**KIRKLEES METROPOLITAN COUNCIL
INVESTMENT & REGENERATION SERVICE**

DELEGATED DECISION TO DETERMINE PLANNING APPLICATIONS

Reference No:	2024/62/91927/E
Site Address:	Grange Nurseries, North View Road, East Bierley, BD4 6NS
Description:	Erection of extensions and front and rear dormers, alterations to dwelling and formation of private access road
Recommending Officer:	Elenya Jackson

DECISION – REFUSED

AS PROPOSED
FRONT FACING ROAD END AND REAR ELEVATIONS

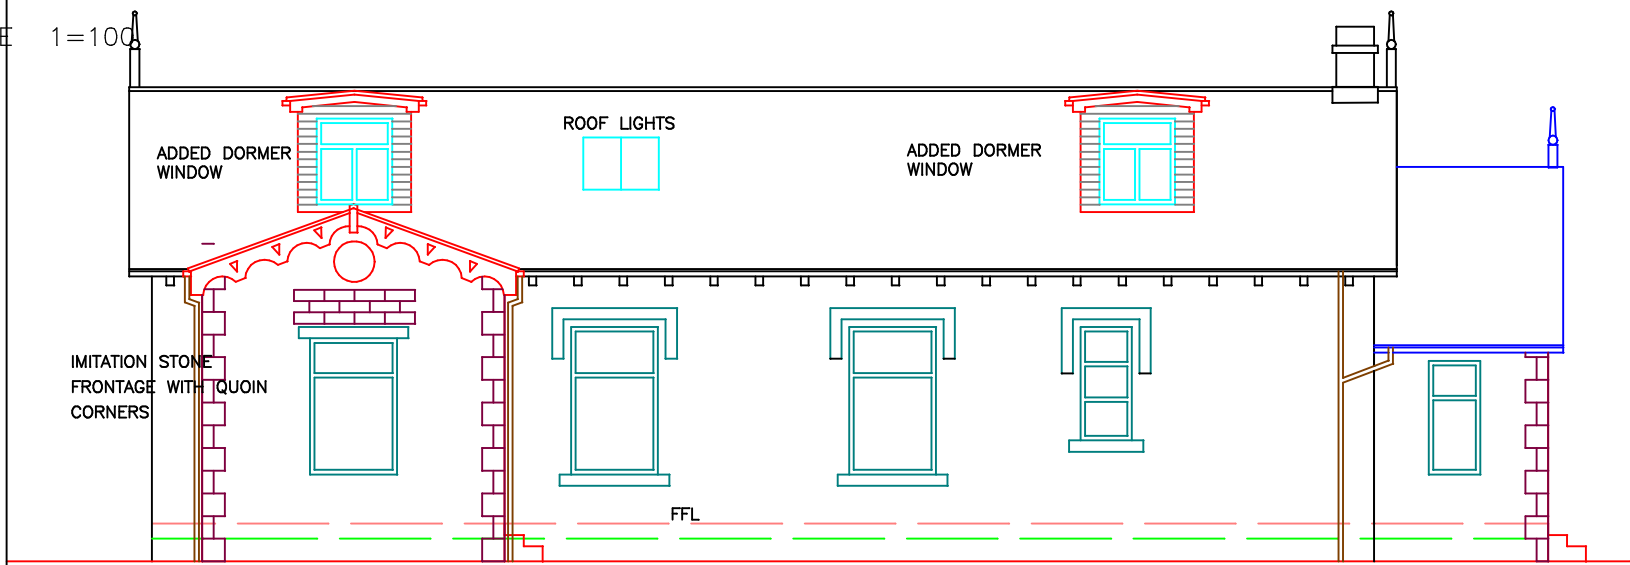
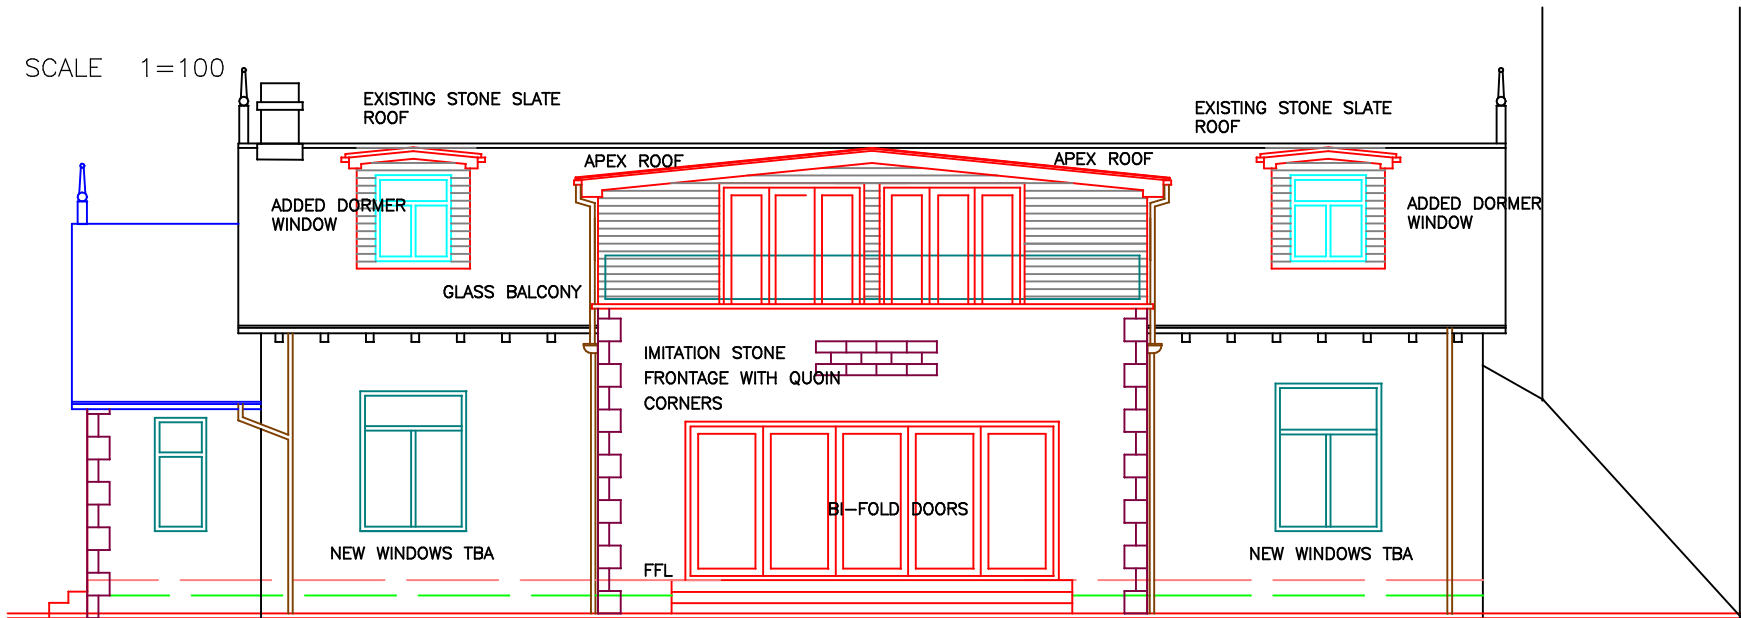
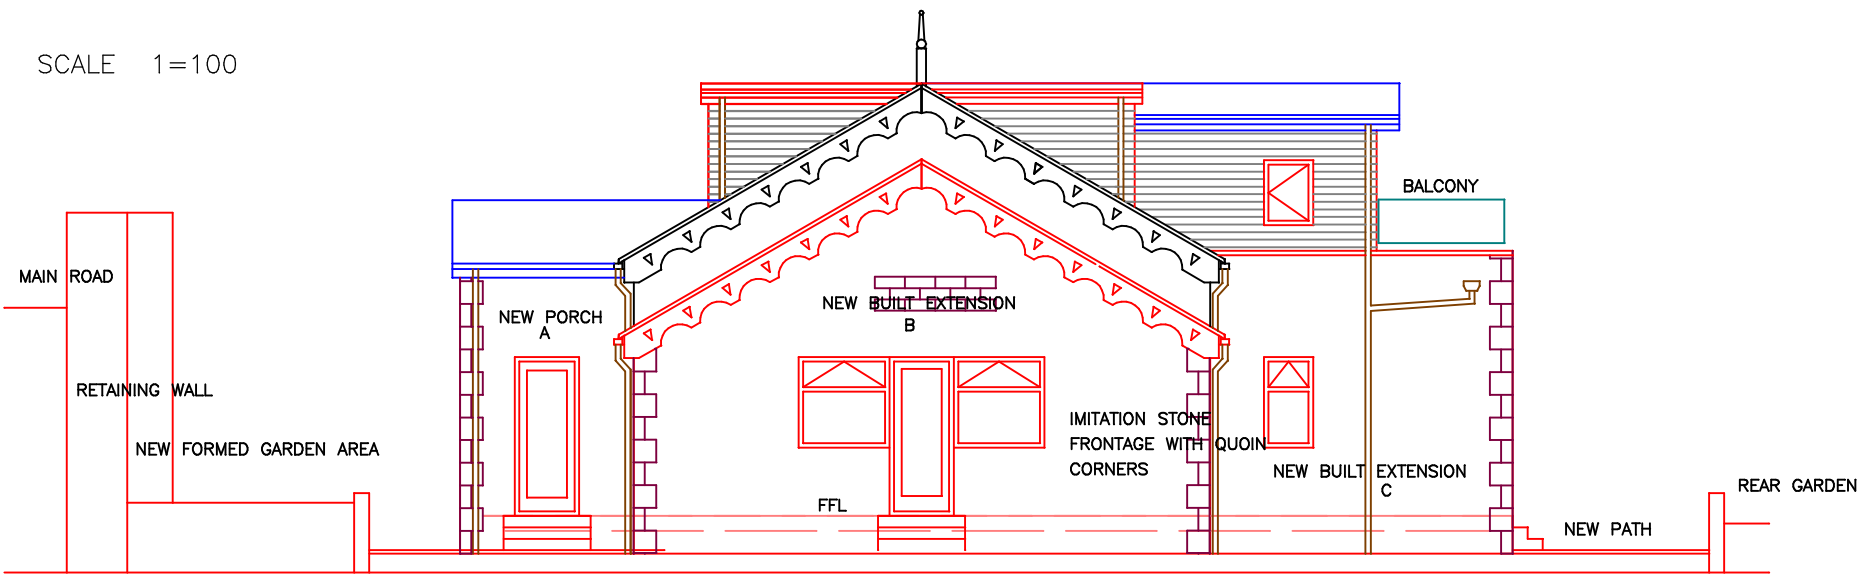
The proposal would have an extension to the western elevation of the property. This is in the same location as the existing a-symmetric projection on the dwelling. The proposal would feature a pitched roof, extend 2.3m beyond the side elevation of the dwelling and have a depth of 7.6m. The extension would have a maximum height of 5.7m.

The extension on the northern elevation of the property would replace an existing projection. This would be set down from the street scene due to a change in ground levels. The extension would project 2.3m beyond the principle elevation of the dwelling and have a width of 4m. The proposals maximum height would be 4.6m.

An extension on the southern elevation which would create a balcony looking towards the rear/east of the plot. This would extend 4m beyond the rear elevation of the dwelling and have a width of 7.3m. This would have a flat roof as it would create a balcony with a maximum height of 4.7m.

In addition, the proposal includes a first floor rear extension which would extend from the roof plane of the host dwelling and over part of the single storey rear extension. This would extend a maximum of 6.3m and have a width of 7.3m. The maximum height of this projection would be 2.6m and it would not extend above the ridge of the host dwelling.

Finally, the proposal features two rear facing dormers which would be located either side of the large first floor extension. The width of these would be 1.5m.

Officers consider that the extension to the northern elevation of the property would replace an existing projection and would better integrate with the host dwelling. The proposal would largely be in the same location as the existing extension and therefore would have an acceptable impact on the host dwelling.

Officers consider that the proposal would be an acceptable scale to not dominate the host dwelling. Although the proposal would have a maximum height of larger than 4m, it is considered that this is not significantly dissimilar to the existing structures on site.

It is considered that whilst the rear extension would extend 4m beyond the rear elevation of the host dwelling this is considered acceptable in the case of detached dwellings. This would allow for a rear facing balcony. Officers

consider that a balcony in this location would be in a suitable location due to it not being near neighbouring dwellings and located at the rear of the dwelling.

The first-floor extension would be at the rear of the dwelling. It is considered that this would not increase the maximum height of the dwelling or its integration with the street scene as it would not be highly prominent from the public realm.

CLIENT	MR AND MRS S, O'BRIEN 34 THORNEDENE WAY, TONG, BRADFORD BD48NW.		
PROJECT	REFURBISHMENT OF BUNGALOW AT GRANGE NURSERIES WEST GATE HILL TONG BRADFORD BD4 6NS		
DETAIL	EXISTING AND PROPOSED BLOCK PLAN OF FULL AREA		
SCALE	1=1000 1=200	DATE	JULY 2024
DRAWN BY	AH	DRAWING NO	O' BRIEN FILE D3

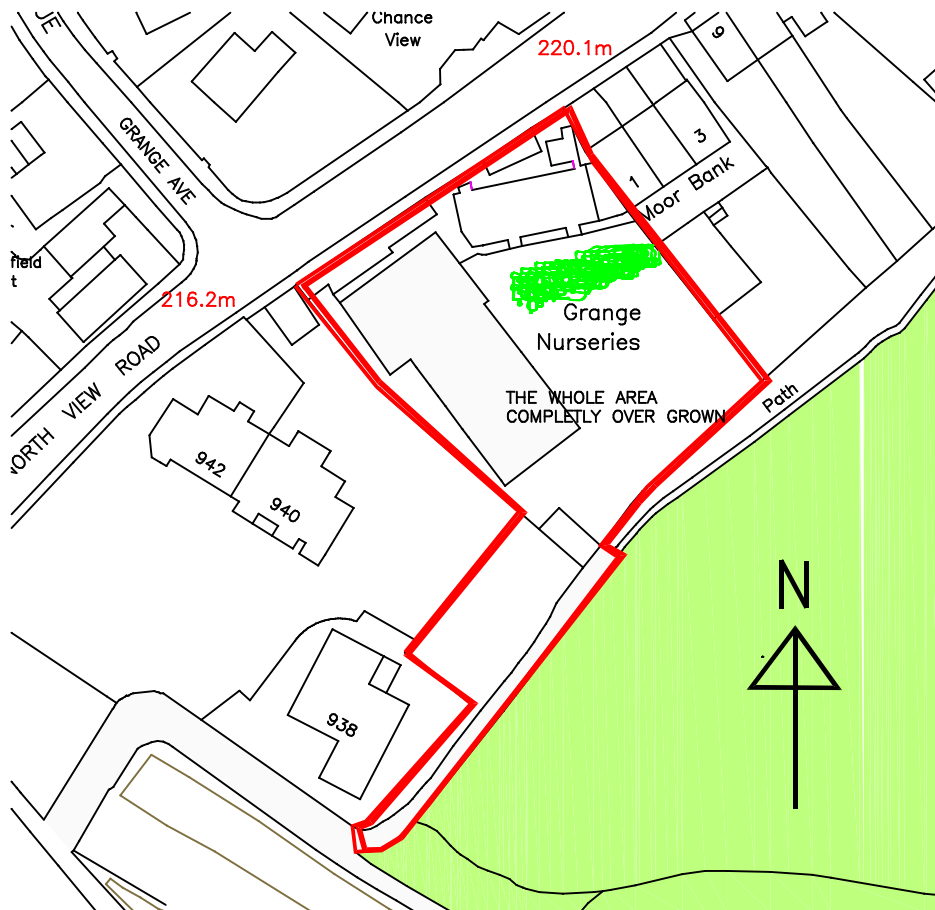
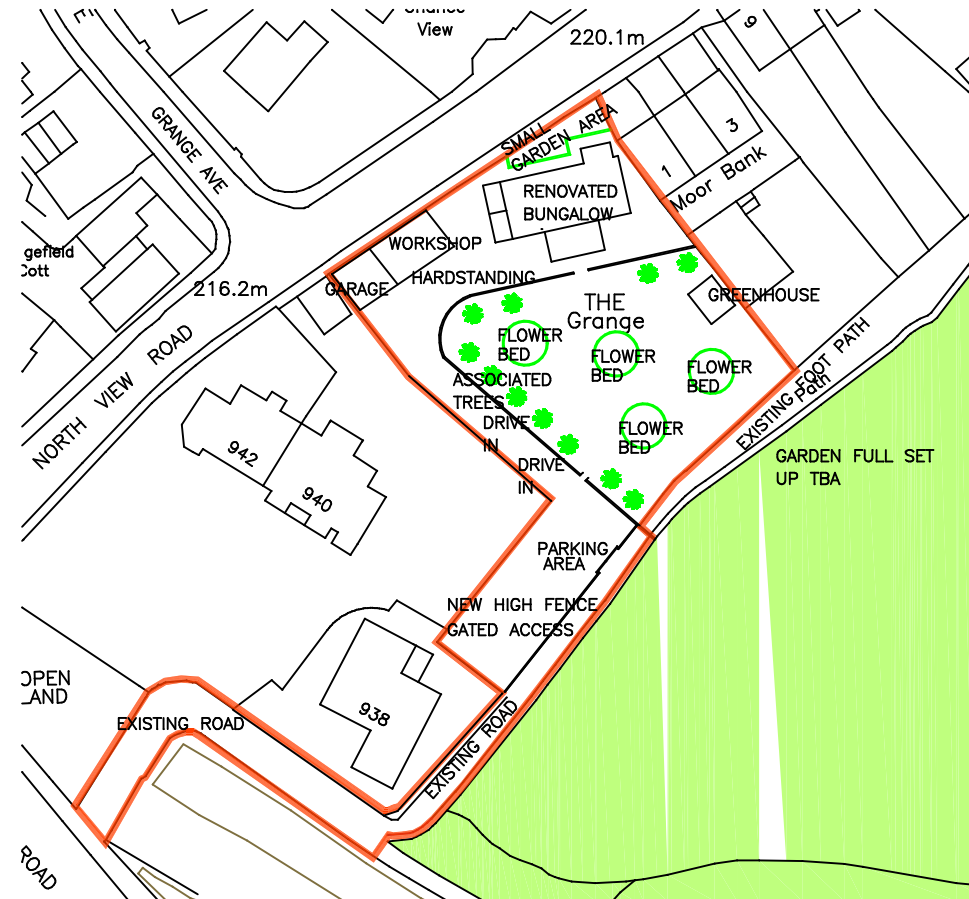
The proposal would result in the small scale loss of urban green space through the introduction of urbanising features (surfacing) to the existing urban green space and would see vehicular movements over the land. It is considered this would lead to a further loss in terms of the appearance of the Urban Green Space whereby the land would have appearance as not being free from development and being land not accessible for use by the public.

From a visual perspective, the proposed alterations to the access of the site would result in cars exiting onto Bradford Road which is already characteristic of the area. However, the creation of the access would have a visual impact

insofar as it would see surfacing undertaken to facilitate the development, and appears to indicate an area of hardstanding to be created to facilitate vehicular parking.

This would see currently open land which is used for open space and recreation partially developed with a driveway which would be used in connection with a nearby property and have the appearance of being land which is not within the public domain. The visual impact would be at odds with that of the wider locality which is soft landscaping and would appear to be out of character with the visual amenities of the locality.

It is considered the visual impact of creating an access, over land used as open space for recreation purposes, would not be in keeping with the use of the land over which it would be taken and it is considered it would have a detrimental visual impact in this regard conflicting with policy LP24 of the Kirklees Local Plan and policies within Chapter 12 of the NPPF.

KC Highways and KC PROW have been consulted on the application due to the site proposing a revised access using land which is currently a Public Right Of Way and exiting onto a classified Road.

KC PROW have objected to the application as the land which the public footpath is located upon is in the ownership of the council and registered as common land.

Public footpath 'Spenborough 8' is indicated to be the access to the development site and currently does not have vehicular access and the Council's Rights Of Way Team confirm they object to the creation of a vehicular access as it would cause a conflict between path users and vehicles.

Officers consider that the proposal would fail to accord with LP23 of the Kirklees Local Plan as the proposal would prejudice the function of a core walking and cycling network. The PROW is not currently utilised for vehicular access and no appropriate mitigation measures to ensure the protection of the PROW or users has been provided.

The proposal would make alterations to the site layout including parking provision and require a new access to facilitate the development, it is considered that the proposal fails to demonstrate that a suitable access could be achieved on site and the proposal would therefore fail to accord with LP21 of the Kirklees local plan.

1. The development would see the loss of urban green space which would conflict with the requirements of policy LP61 of the Kirklees Local Plan and paragraph 104 of the National Planning Policy Framework.

2. The application would have an unacceptable impact on a public footpath (ref: SPE/8/60) and the subsequent amenity and enjoyment of users of this public right of way. The development would prejudice the function and continuity of the core walking and cycling network and fail to ensure the safe and efficient flow of pedestrian traffic. The proposal would therefore fail to accord with policies LP21 and LP23 of the Kirklees Local Plan.

3. The visual impact of creating an access, over land used as open space for recreation purposes, would be out of keeping with the use of the land over which it would be taken and have a harmful resultant visual impact conflicting with policy LP24 of the Kirklees Local Plan and policies within Chapter 12 of the NPPF.
